EAST PRESTON PARISH COUNCIL

19th December 2018

Re: EP/166/18/HH – 100 Sea Road, East Preston, BN16 1NP

Printed As Shown on A1
Date 12/11/2018
Drawing Number 18075/01

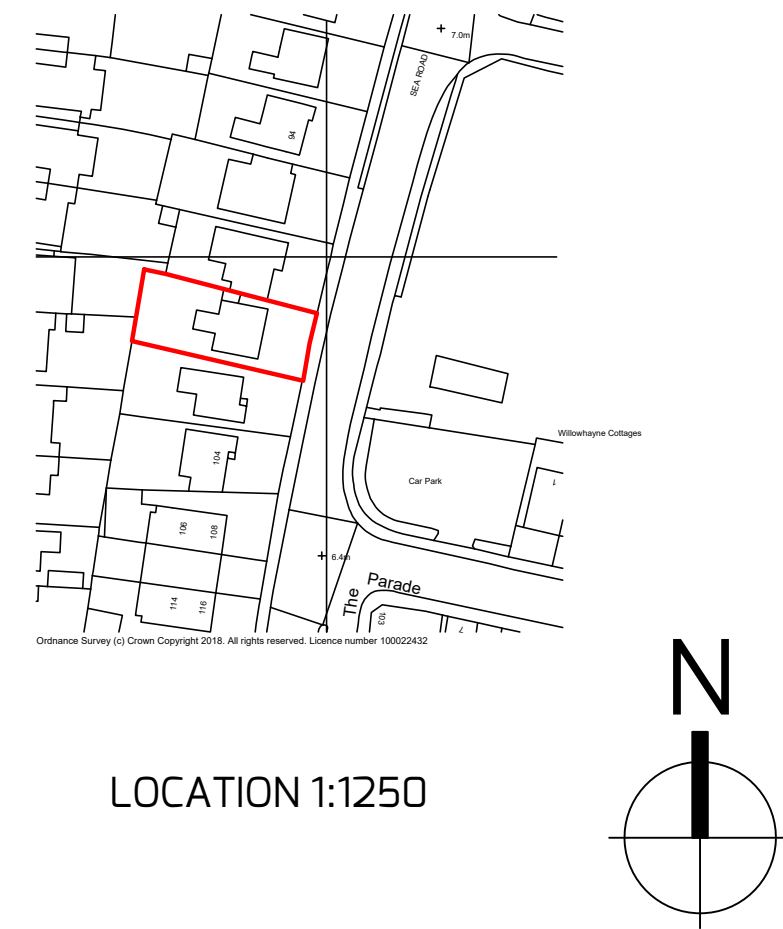
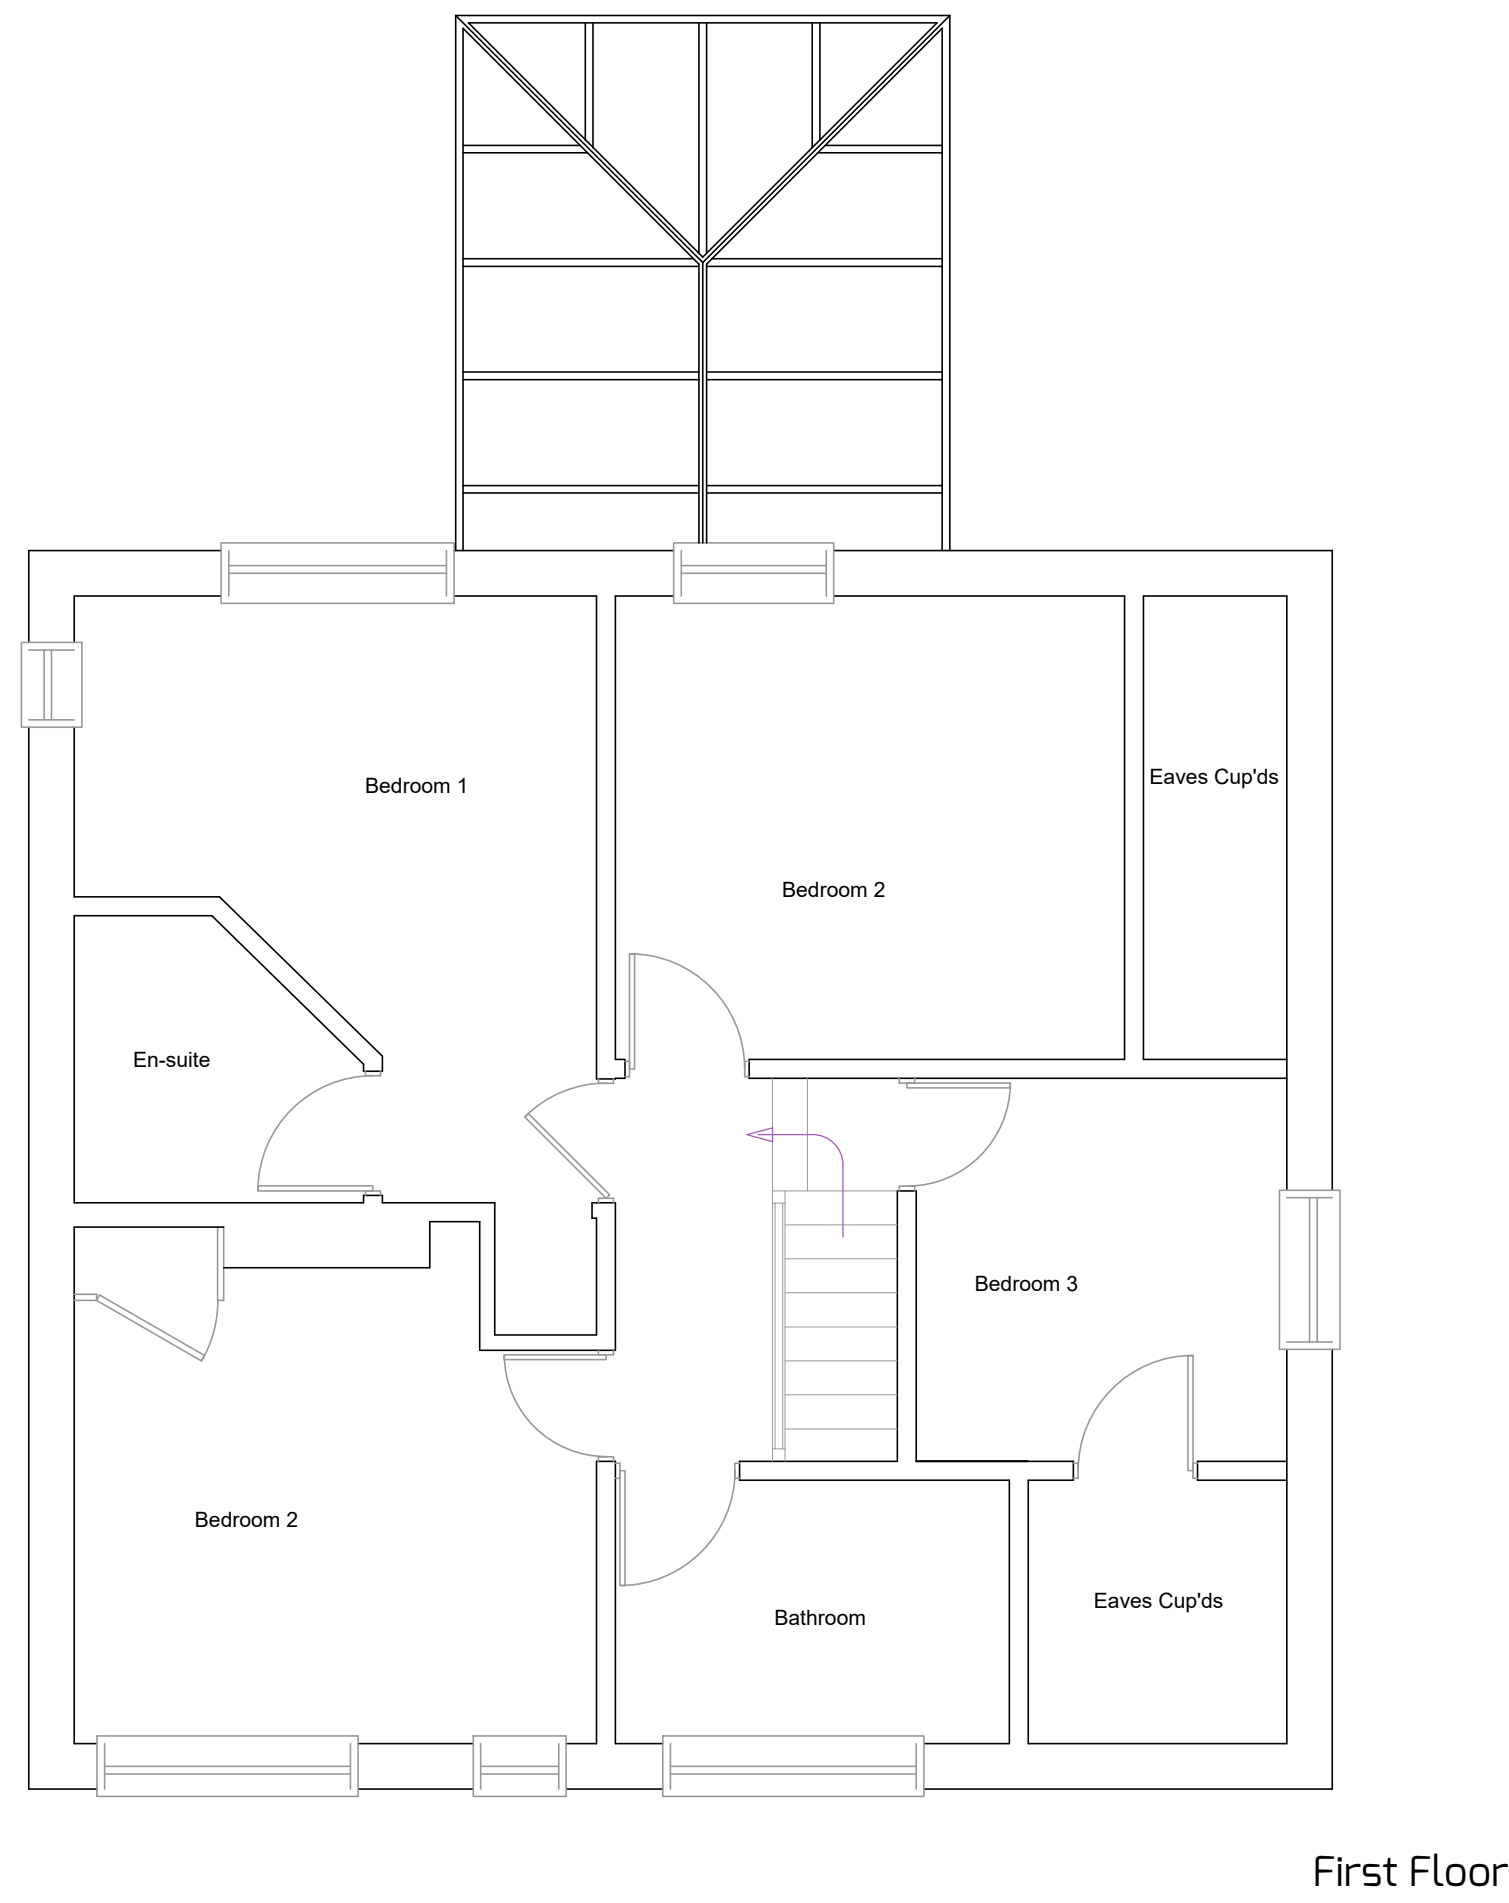
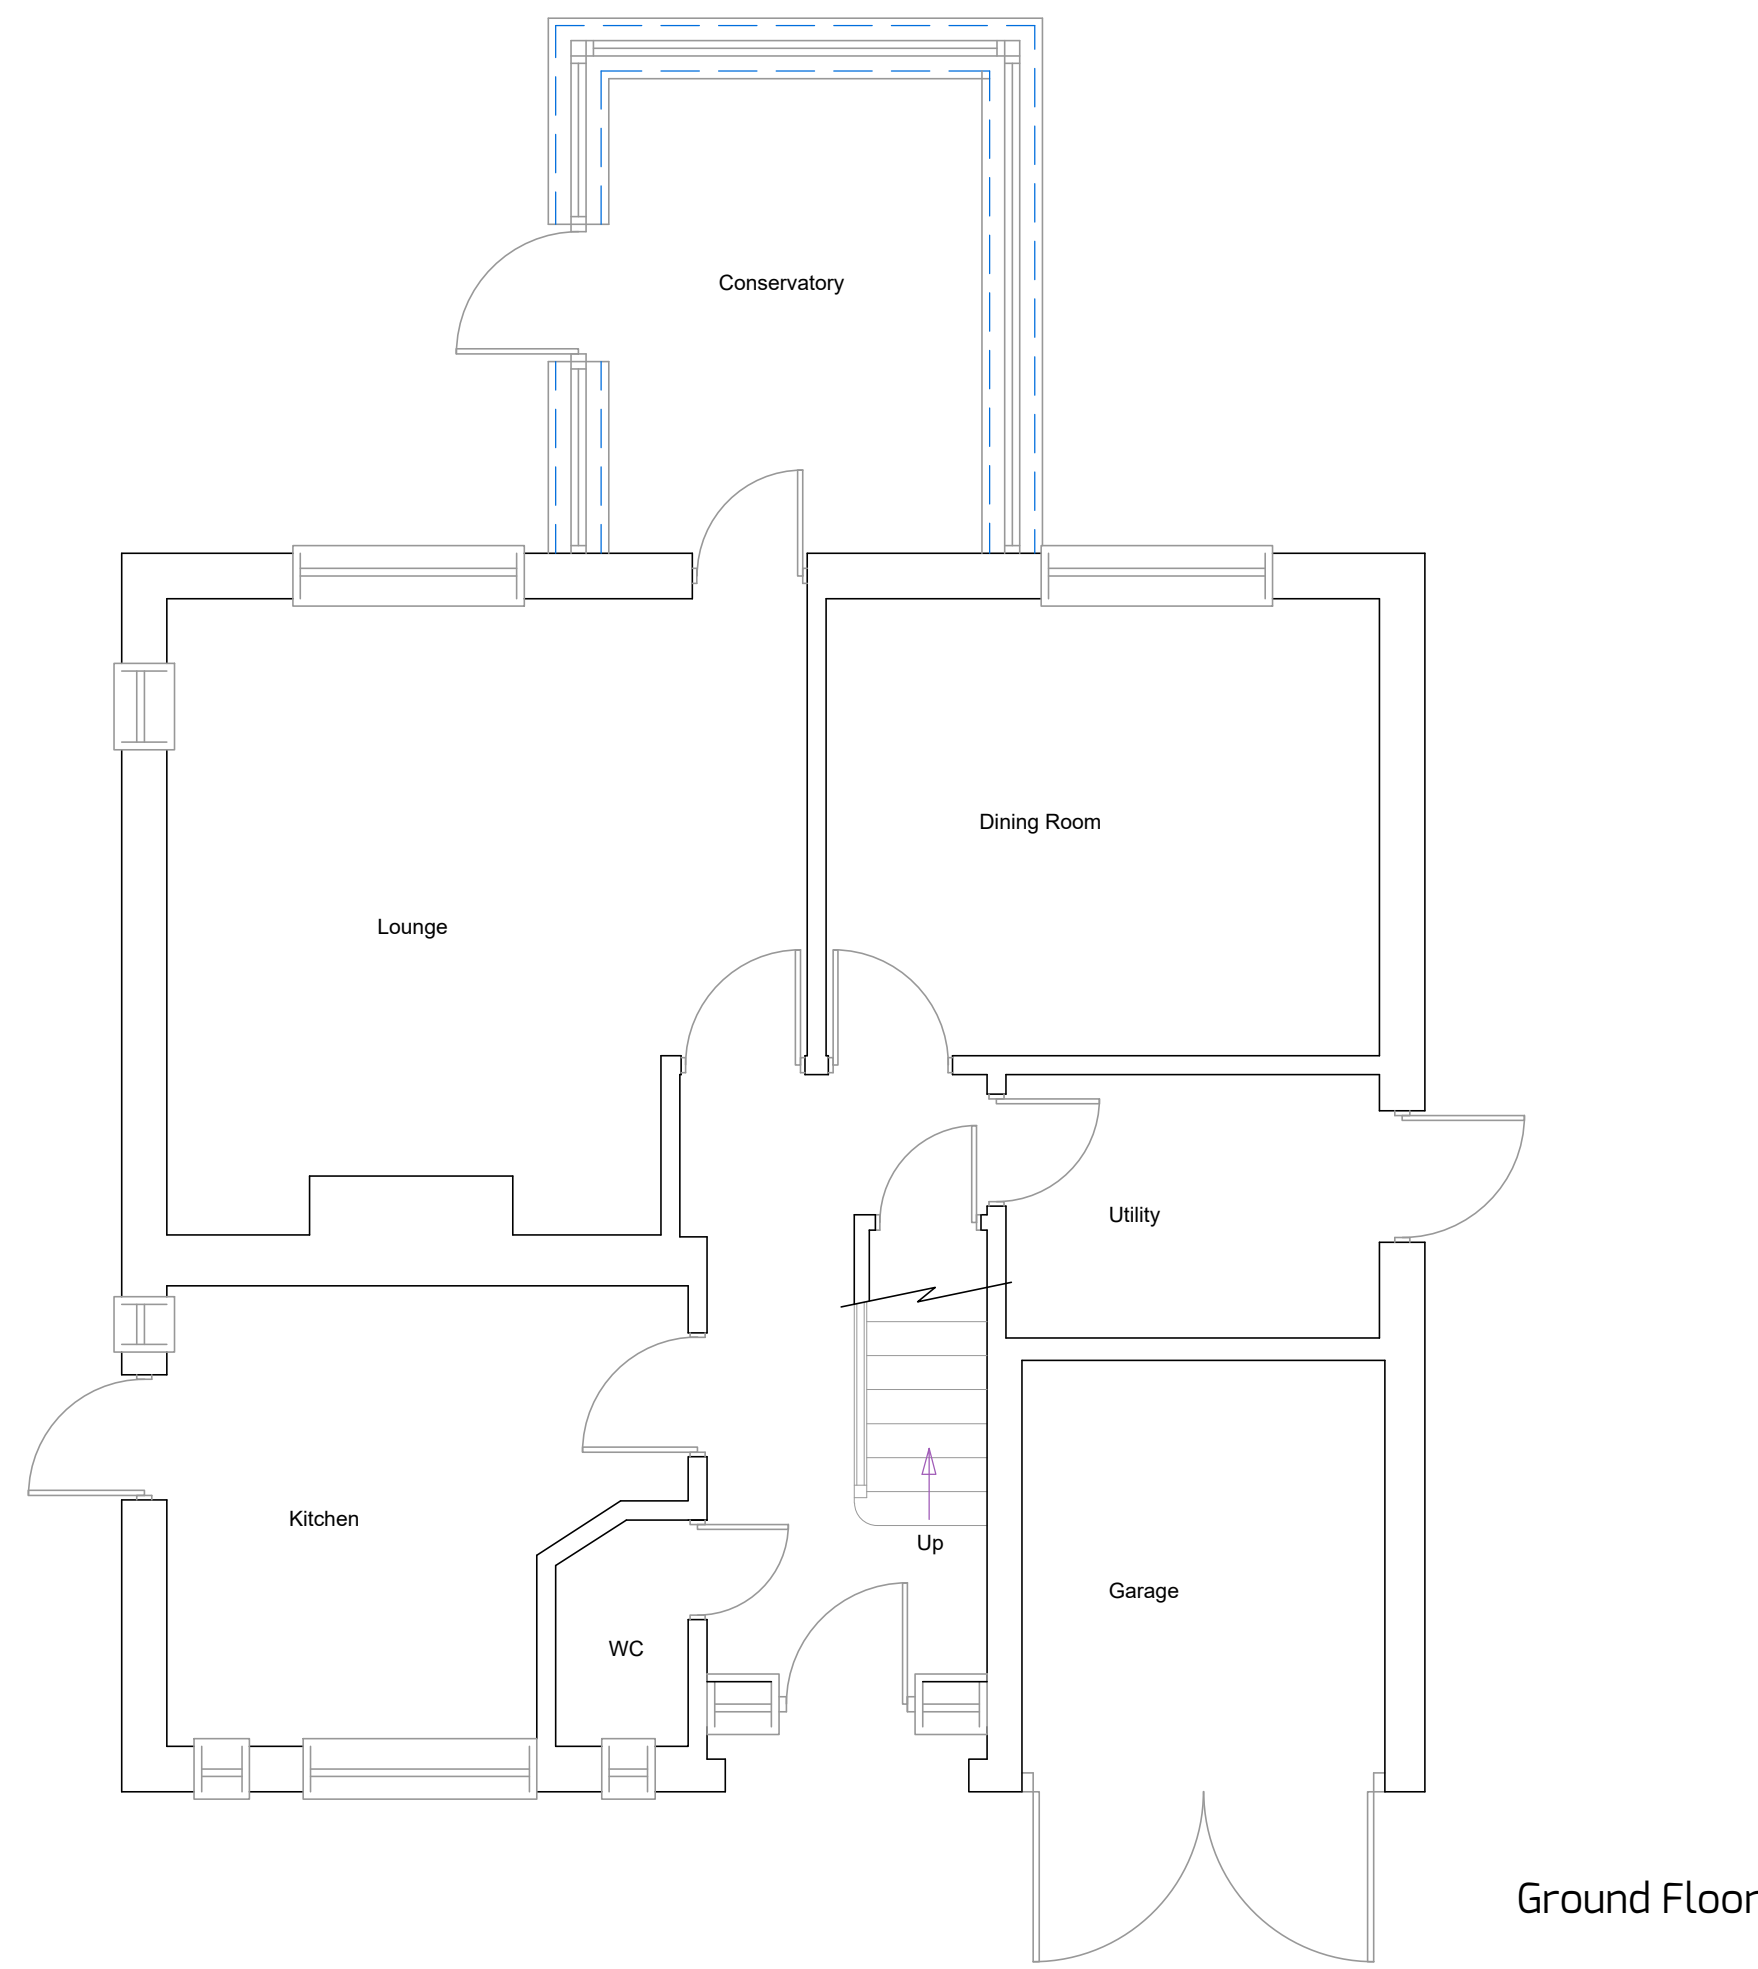
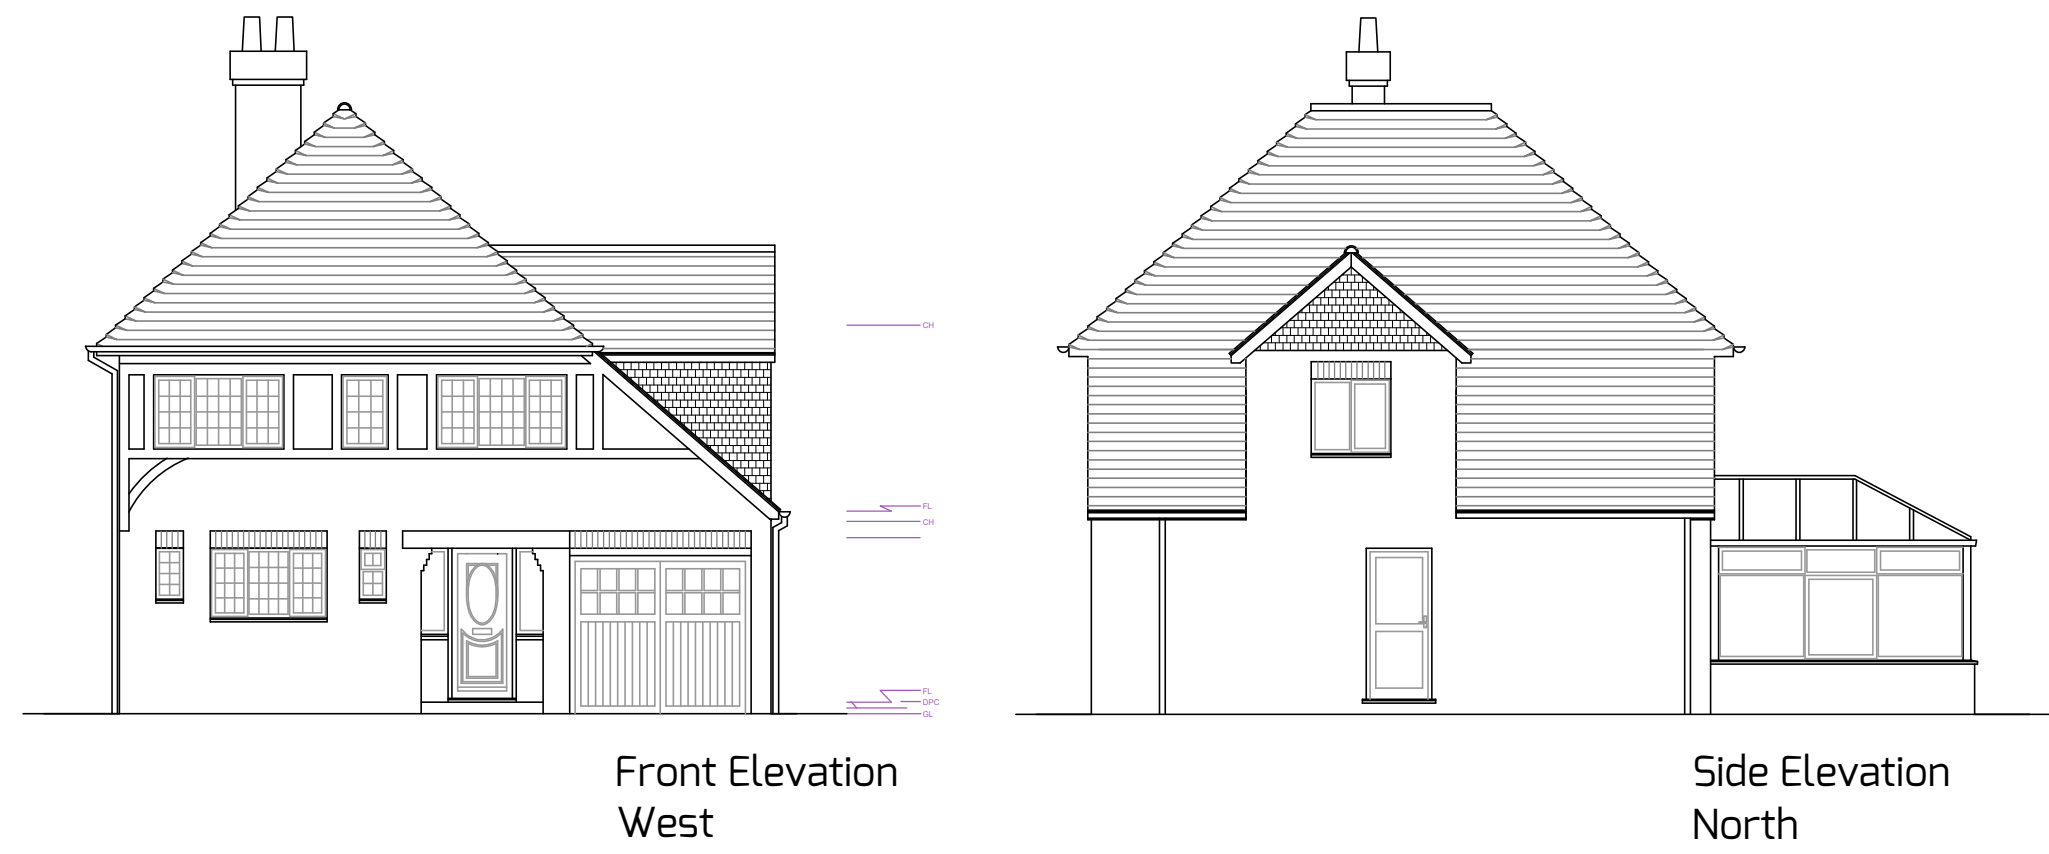
The existing dormer on the northern elevation of the property will be lost but matches with the dormers on the two properties immediately to the north of this property. This will have an unacceptable impact on the host property and unacceptable negative impact upon the uniform character and appearance of neighbouring properties in conflict with Policies D DM1 and D DM4 of the Arun Local Plan and the National Planning Policy Framework.
